Director Infrastructure Projects
Department of Planning and Environment
Major Projects Assessment
GPO Box 39
SYDNEY NSW 2001

PROPOSED NORTHCONNEX M1 / M2 TUNNEL PROJECT - Application Number - SSI 13_6136
We object to many aspects of this project

MOTORWAY OPERATIONS COMPLEX - SOUTHERN VENTILATION FACILITY - SECTIONS
M1-M2-5000-DR-JD-0525

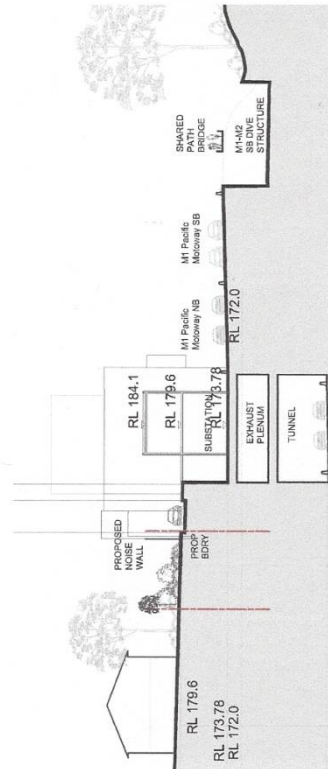
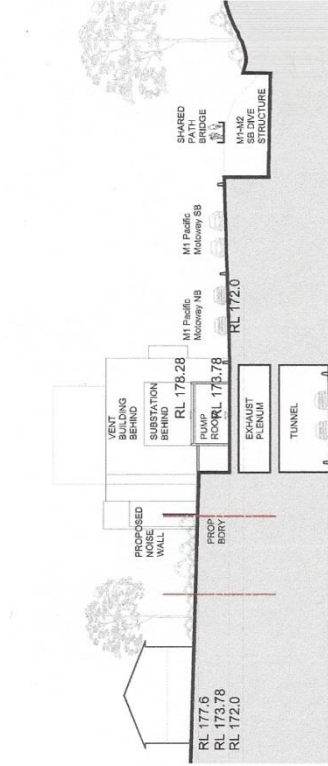
1. The Environmental Impact Statement (EIS) does not show any connection between the ventilation stack and the southbound tunnel which is 250 metres away. Will the polluted air be allowed to flow like an invisible sewer through West Pennant Hills, North Rocks, Carlingford and Beecroft?
ACTION: Provision of diagrams and detailed description of what ventilation is proposed for the southbound tunnel at the Southern Interchange. We would like the opportunity to lodge further submissions once that has been provided.
